Your ref
AL/77/19/HH

Our ref
PLAN-030018

Proposal: Enlarged replacement single storey extension with bathroom and dressing room in roof space.

Site: AL/77/19/HH: - 2 Tudor Cottage, Tudor Drive, Westergate, Aldingbourne, PO20 3YT.

Site plan 1:250

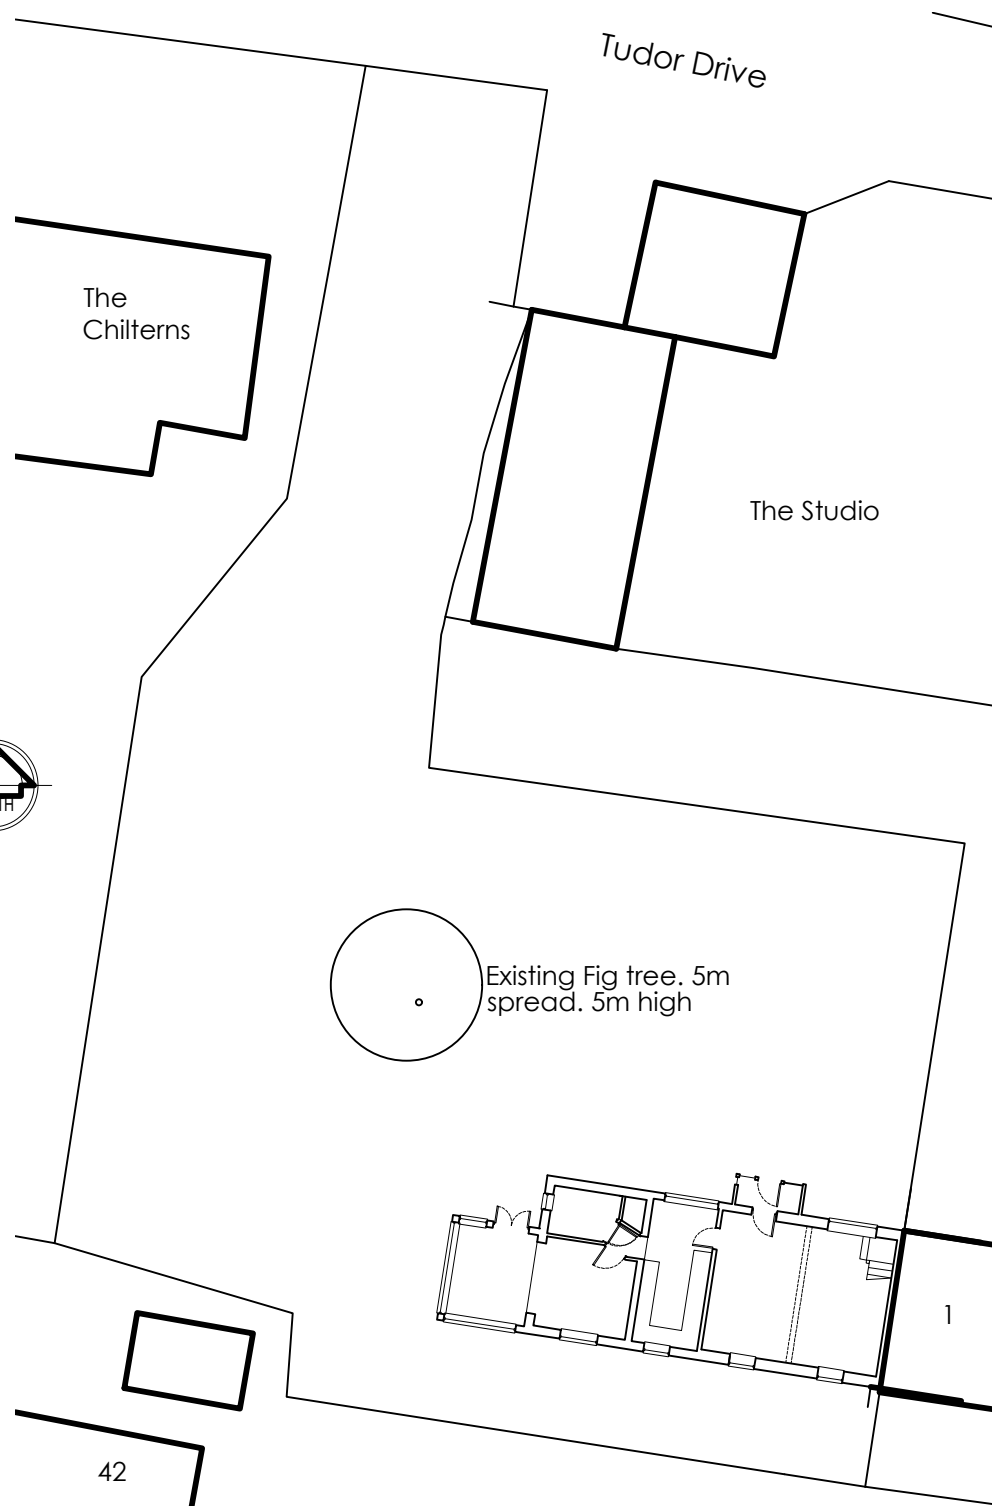
Please find attached a plan of the sewer records showing the approximate position of a public foul sewer crossing the site. The exact position of the public foul sewers must be determined on site by the applicant.

- The 150mm diameter gravity foul sewers requires a clearance of 3 metres on either side of the gravity sewers to protect it from construction works and to allow for future access for maintenance.
- No development or tree planting should be carried out within 3 metres of the external edge of the public gravity sewer without consent from Southern Water.
- No soakaways, swales, ponds, watercourses or any other surface water retaining or conveying features should be located within 5 metres of a public sewers.
- All existing infrastructure should be protected during the course of construction works.
